CASA Ref: F22/33904-2

Your Ref: SSD-50629707 Email of 2 May 2024

### **CASA ASSESSMENT – THE PLAINS WIND FARM SSD-50629707**

CASA has reviewed the Aviation Impact Assessment (AIA) (Appendix Q to the EIS) by Aviation projects for the proposed The Plains Wind Farm.

Figure 1 Proposed obstacle lighting layout

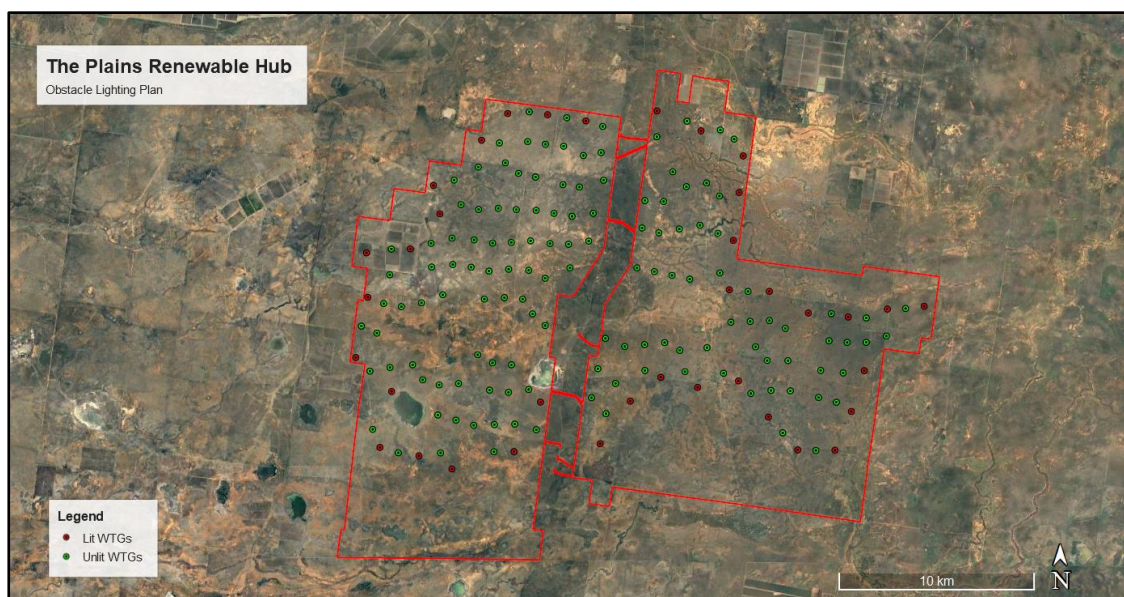
Contrary to Recommendation 7, CASA considers the proposed wind farm will be a hazard to aviation safety and recommends that the wind farm is obstacle lit with steady medium-low intensity red obstacle lighting in accordance with the National Airports Safeguarding Framework Guideline D '*Managing the Risk of Wind Turbine Farms as Physical Obstacles to Air Navigation*' [National Airports Safeguarding Framework Principles and Guidelines \(infrastructure.gov.au\)](#) and section 9.31 of Part 139 Aerodromes Manual of Standards [Part 139 \(Aerodromes\) Manual of Standards 2019 \(legislation.gov.au\)](#).

International standards require, and the NASF guideline recommends, 2,000 candela lighting intensity. CASA recommends that 200 candela as a minimum intensity lighting would suffice. The

obstacle lighting should be monitored to alert the wind farm operator of any outage. The lighting system should have a failsafe mode to ensure that at least some of the obstacle lights remain on during an outage, and a management system developed to ensure any outages are corrected promptly. CASA is prepared to review a lighting plan that indicates which turbines are proposed to be lit.
